Fenwick Solar Project Limited

**Planning Act 2008 – Application for a Development Consent Order for Fenwick Solar Farm**

**Applicant Response to Section 51 Advice Letter dated 29 November 2024**

**Application Ref: EN010152**

**ISSUE/REVISION**

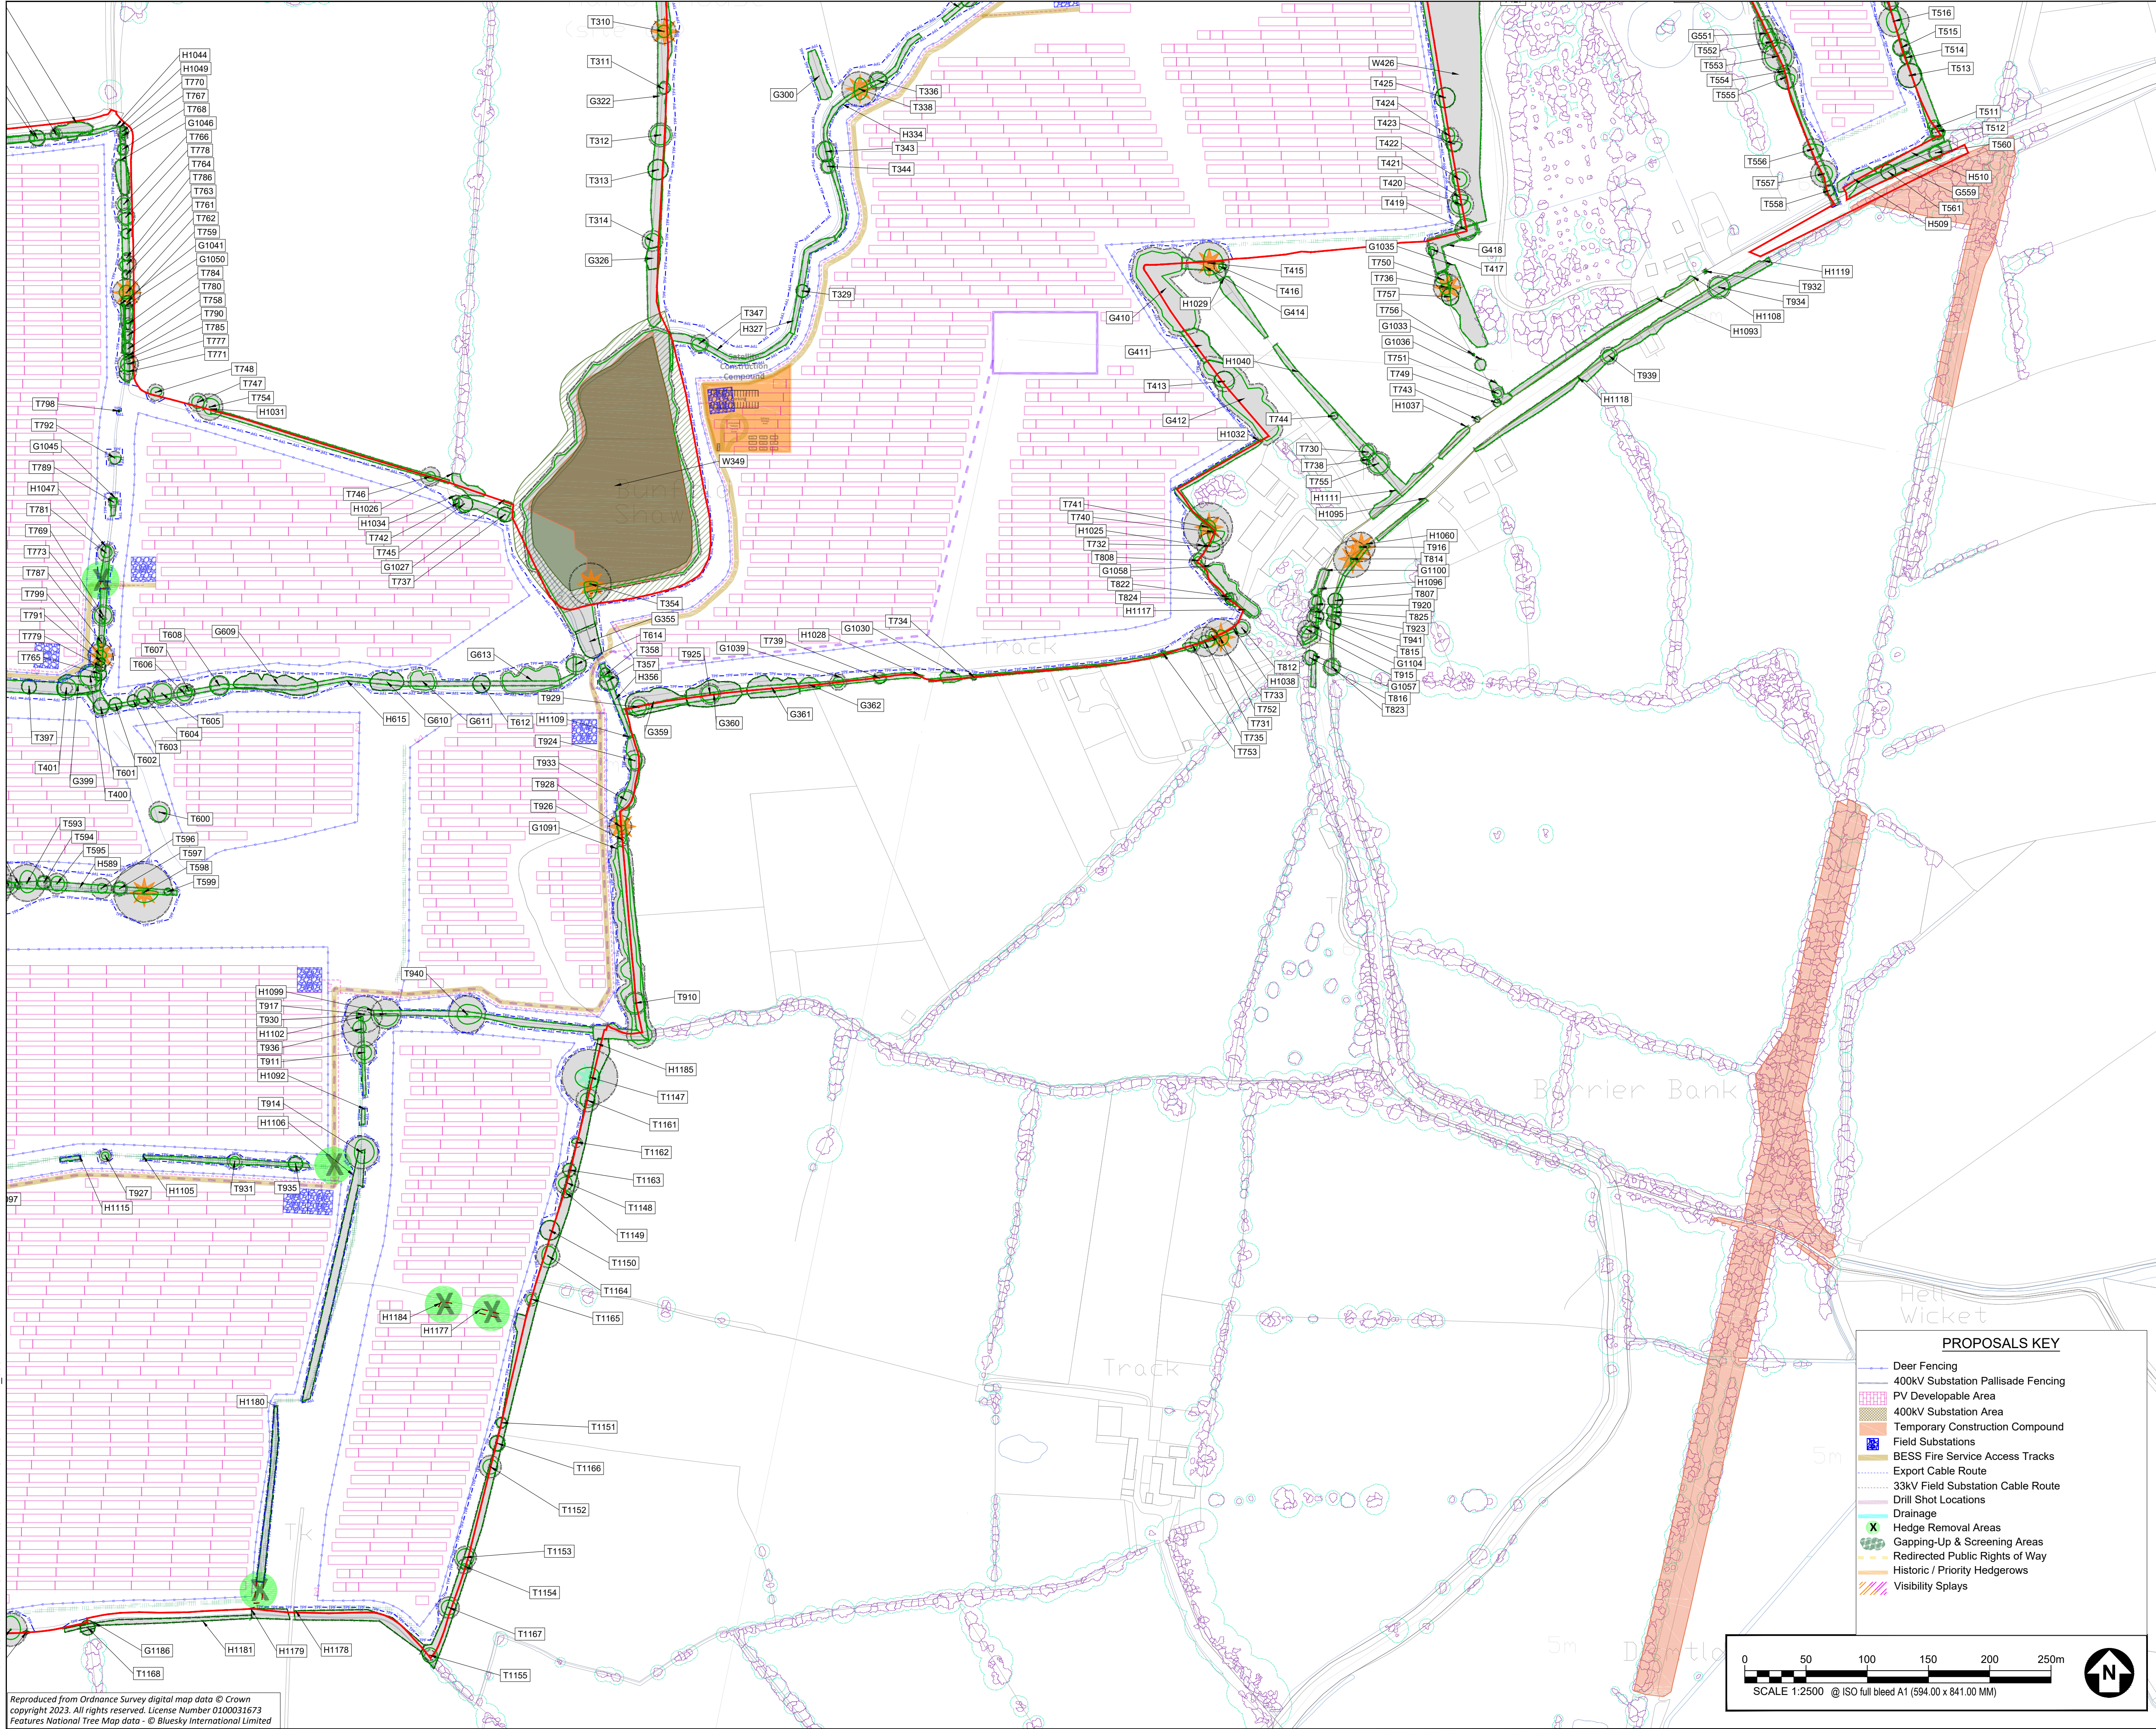
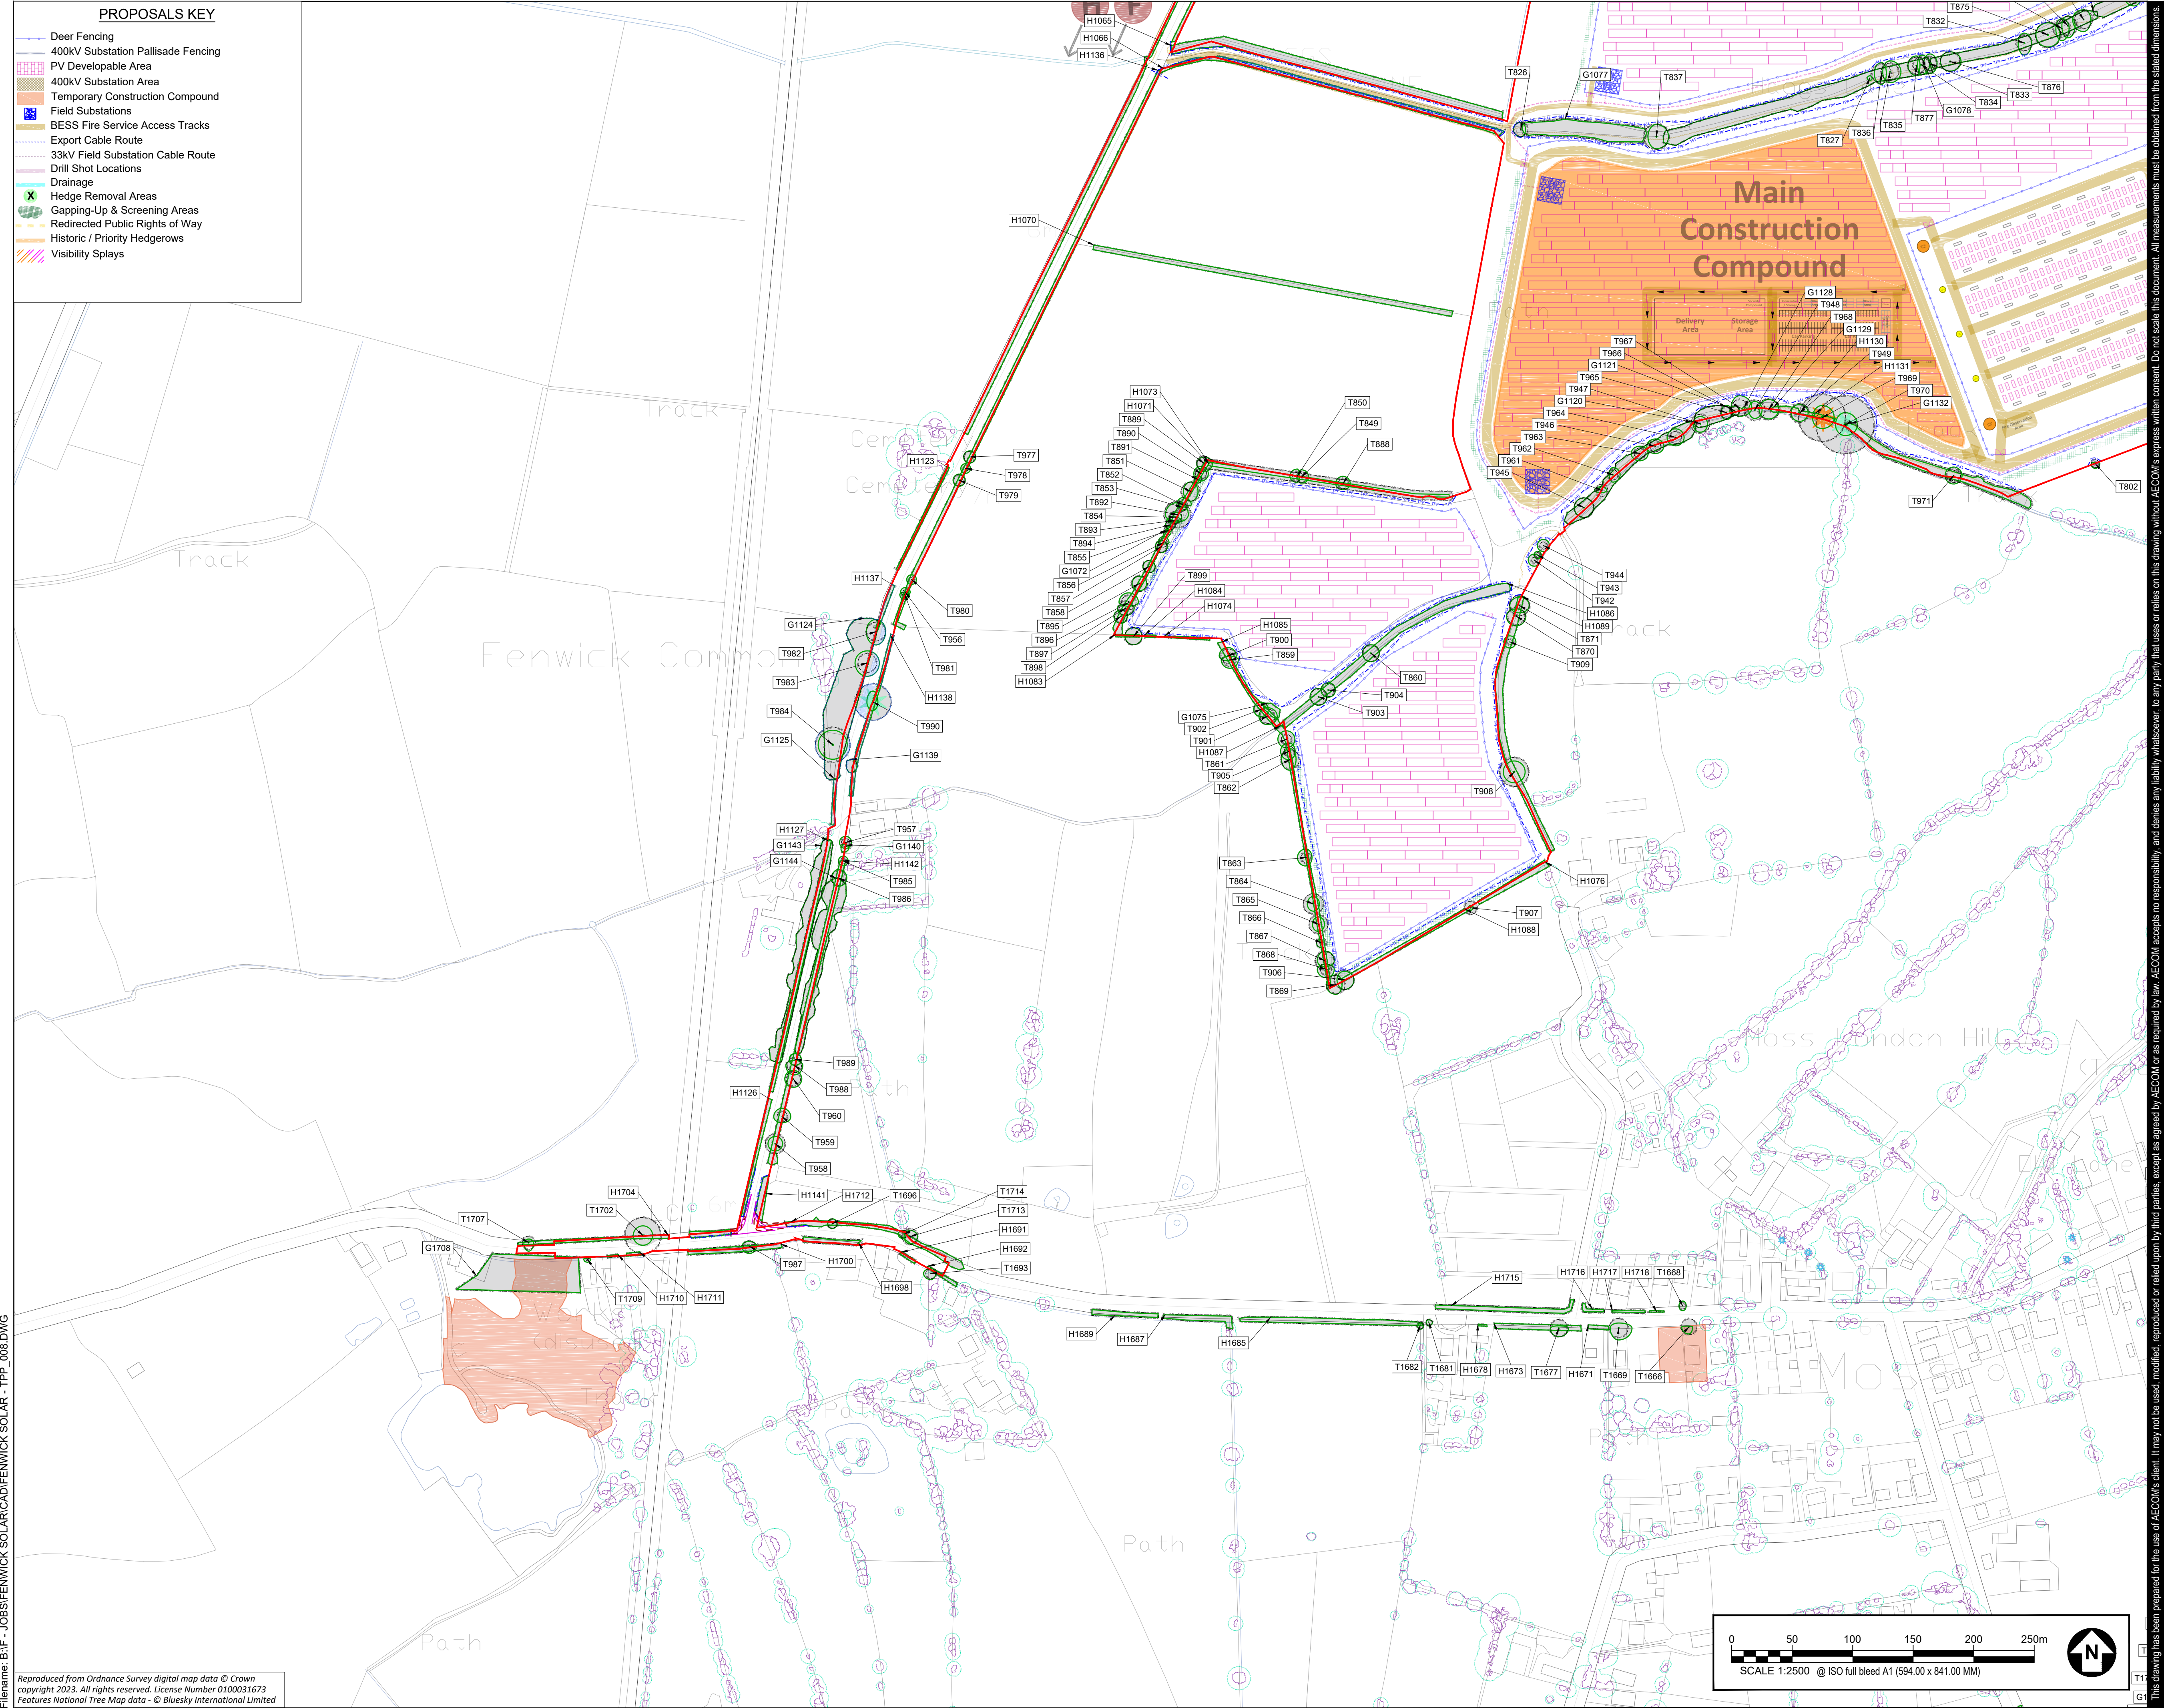
- 1.8.5 **Appendix 10-7: Arboricultural Impact Assessment** (part 1 and part 2) of the Environmental Statement [EN010152/APP/6.3] has been updated by amending the colour scheme of the ancient woodland in both the Tree Constraints Plan and the Tree Protection Plan to provide more contrast between the tree categories and ancient woodland.
